City of Albuquerque

RE: WALGREENS @ UNSER & SAPPHIRE (M-10/D15A)
(1201 Unser Blvd SW)
ENGINEERS CERTIFICATION FOR CERTIFICATE OF OCCUPANCY
ENGINEERS STAMP DATED 10/29/2002
ENGINEERS CERTIFICATION DATED 5/20/2003

**Re: Walgreens @ Unser/Sapphire Grading and Drainage Plan
Engineer's Stamp dated 10-29-02, (M10/D15A)**

DRAWING TITLE
GRADING & DRAINAGE PLAN
HYDROLOGY SECTION

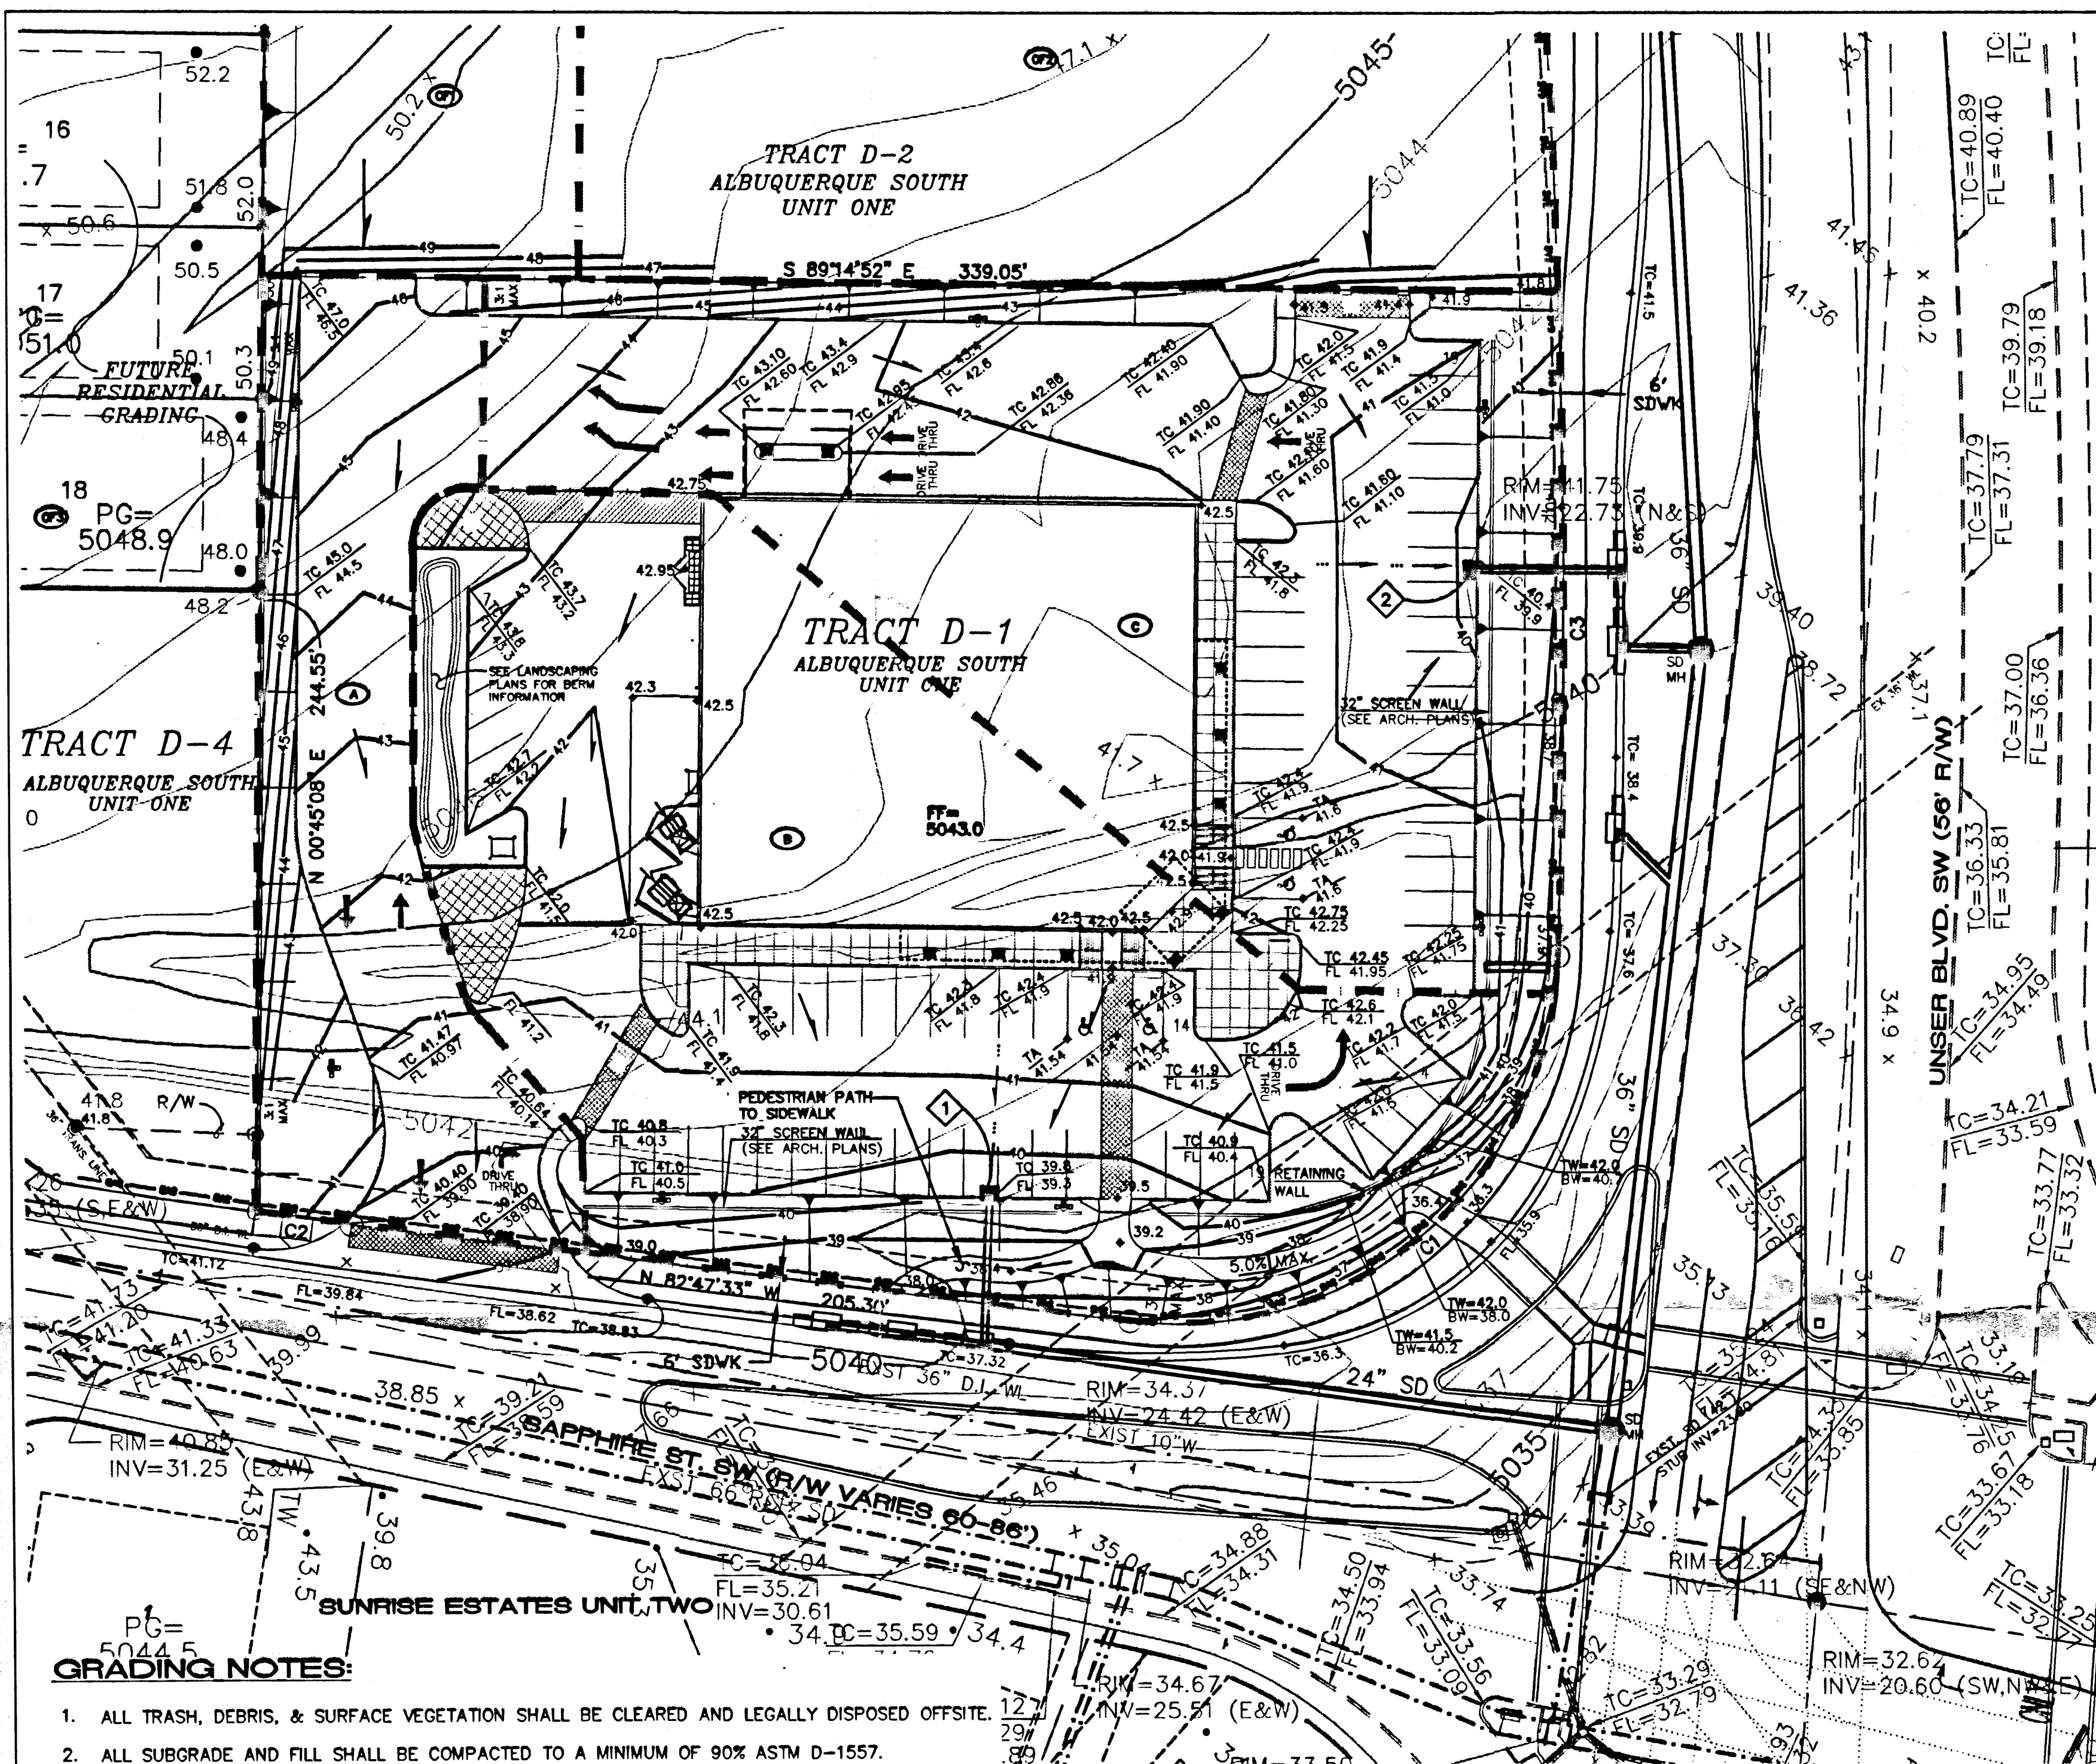
- There is a low point in the profile of the south-to-east lane that should have an inlet installed or redesigned to drain to one of the other proposed inlets.
- The work order infrastructure would have to be accepted by the City.
